Phone: 0300 123 6780
Email: developeras@lancashire.gov.uk
Your ref: 3/2025/0681
Our ref: 3/2025/0681/HDC/KW
Date: 30 January 2026

Location: 14 Lancaster Drive Clitheroe BB7 2PD
Proposal: Proposed partial demolition of existing dwelling, and rebuild with extensions, alterations and roof lift with rear dormer extensions.
Grid Ref: 373257 441471

**Proposed Ground Floor Plan**  
 1 : 50

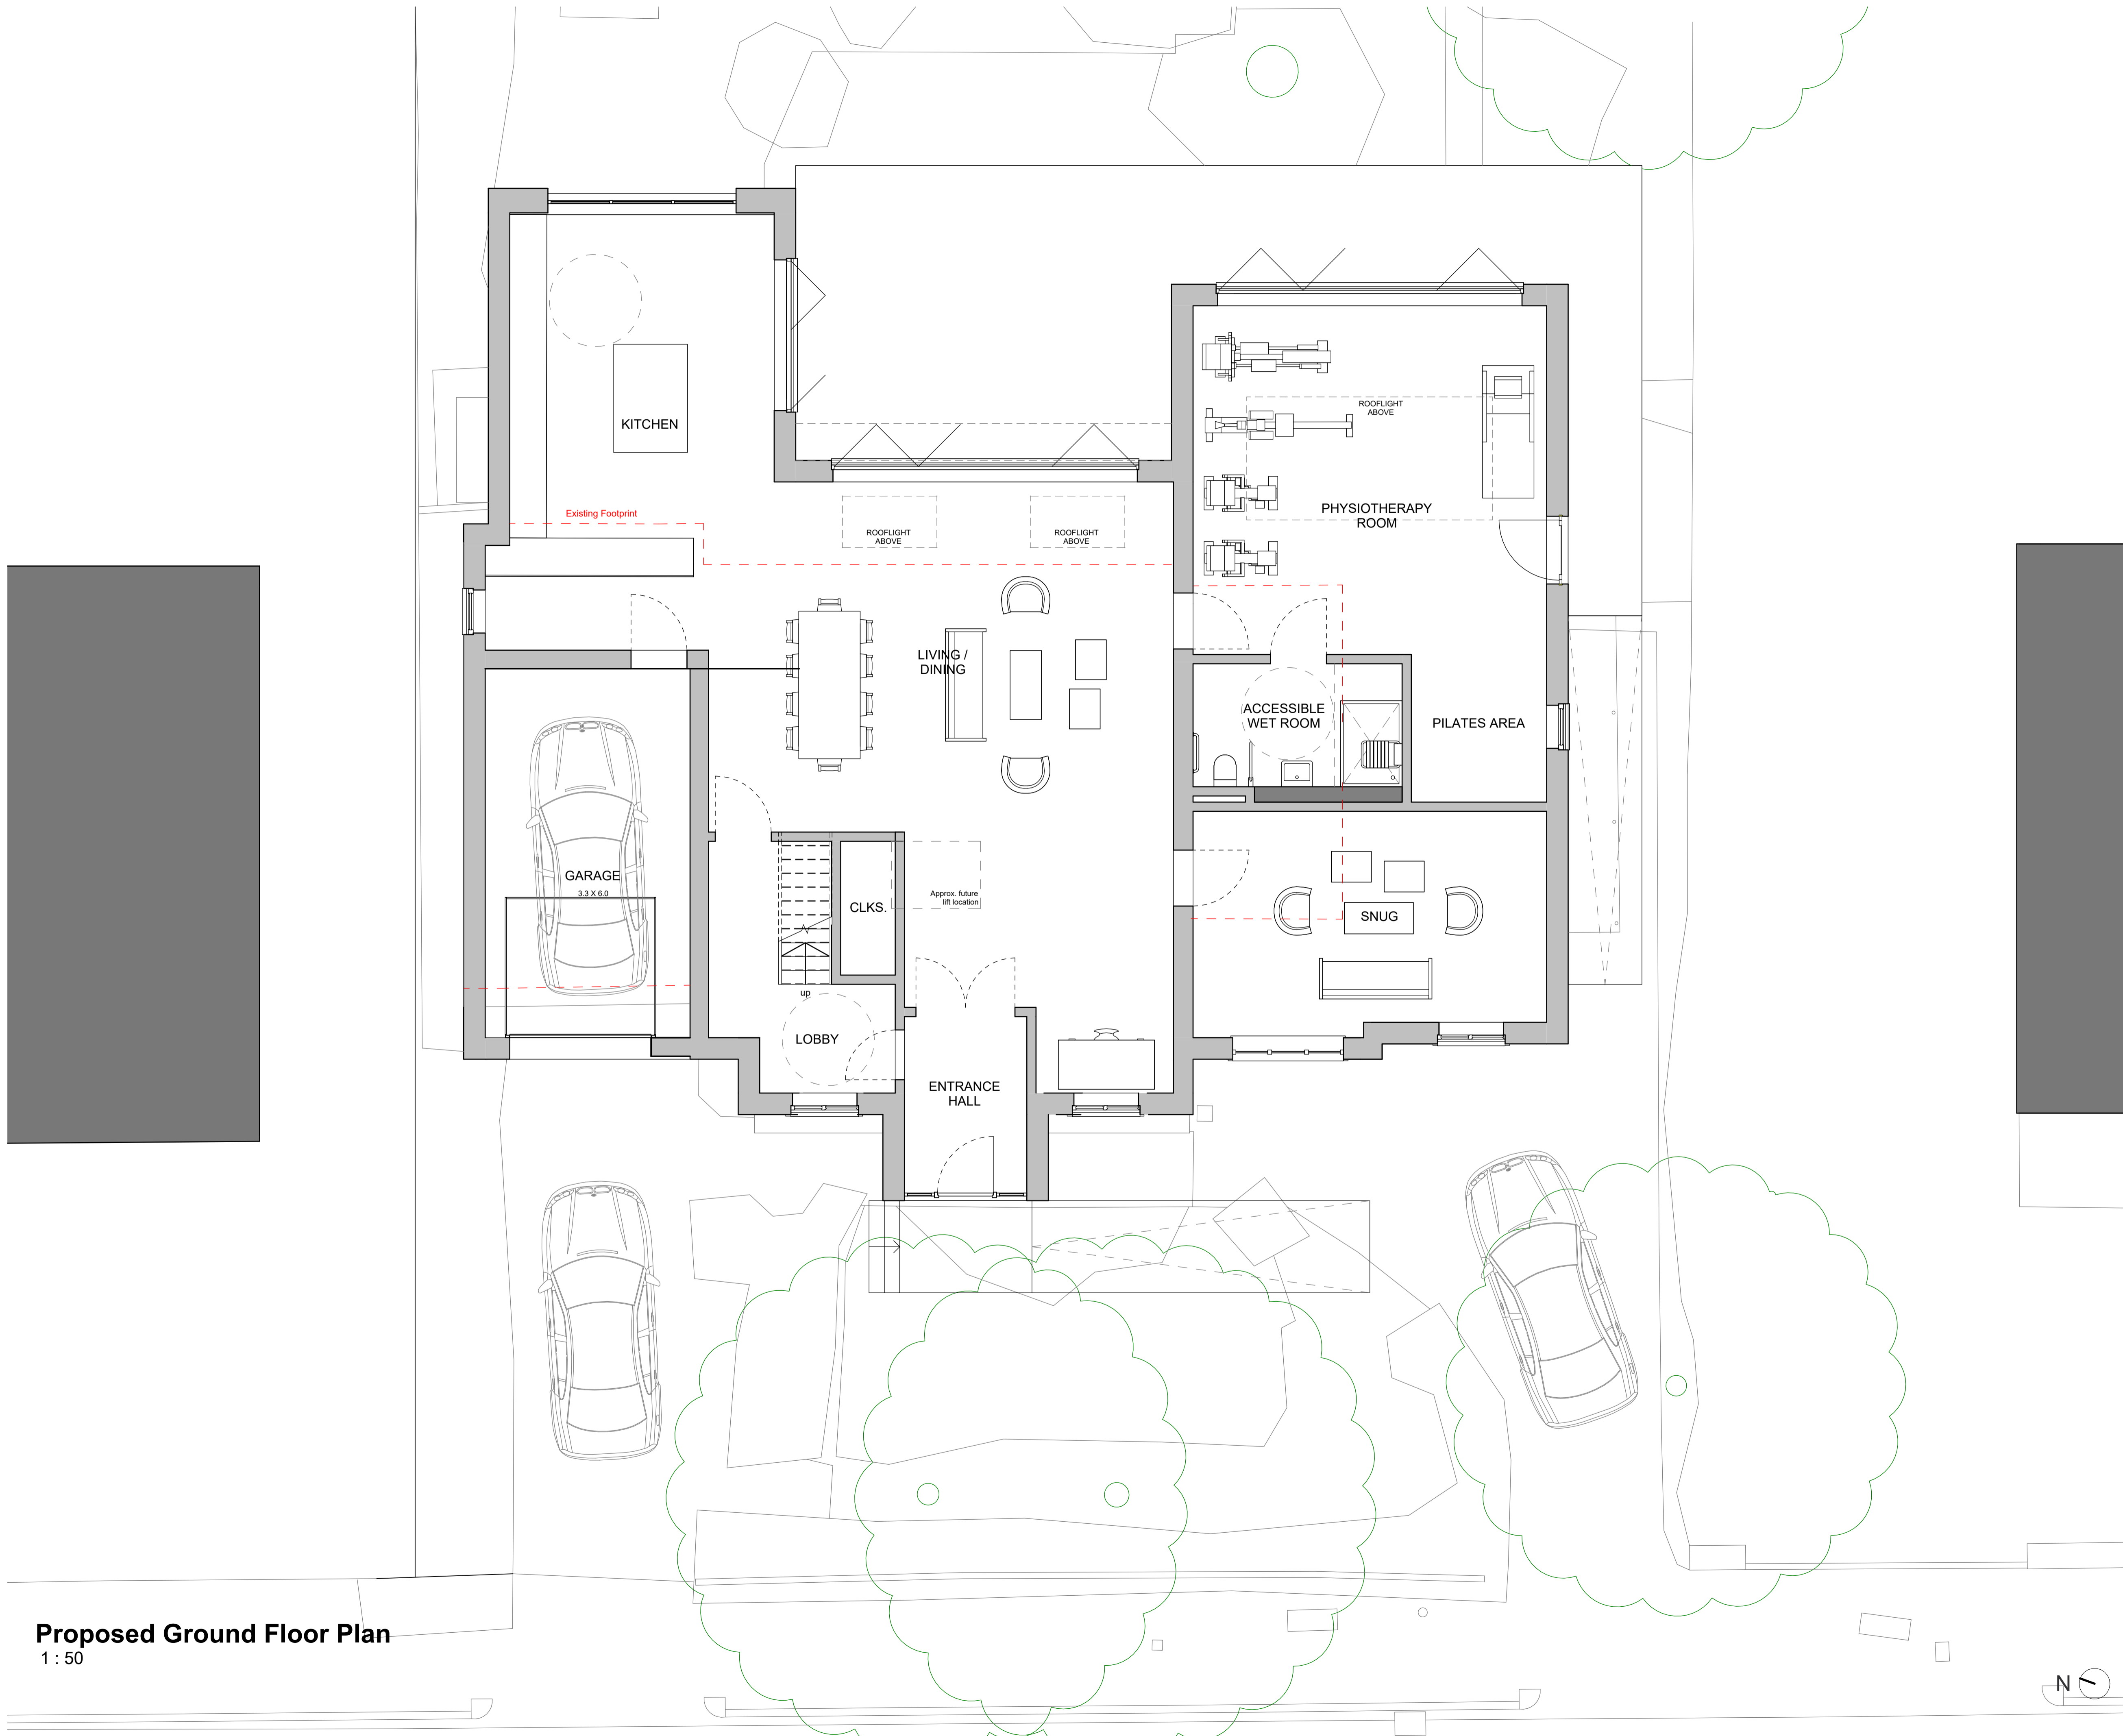
The LHA have reviewed PGB drawing number 0104 revision 2 titled Proposed Ground Floor Plan and are aware that the dwelling complies with the LHAs parking standards as defined in the Joint Lancashire Structure Plan. Therefore, the LHA have no objection to the proposal.

The recommended minimum internal dimensions for a single garage size is 6m in length and 3m wide. The recommended distance of 6m is based on the length of a large family

car (Ford Mondeo Estate 4.58m long), clearance at the rear of the car (200mm), overhang of the garage door (600mm) and room to stand in front of the car and open/close the garage door (600mm). The proposed garage meets the recommend minimum internal dimensions and as such can be counted as a parking space.
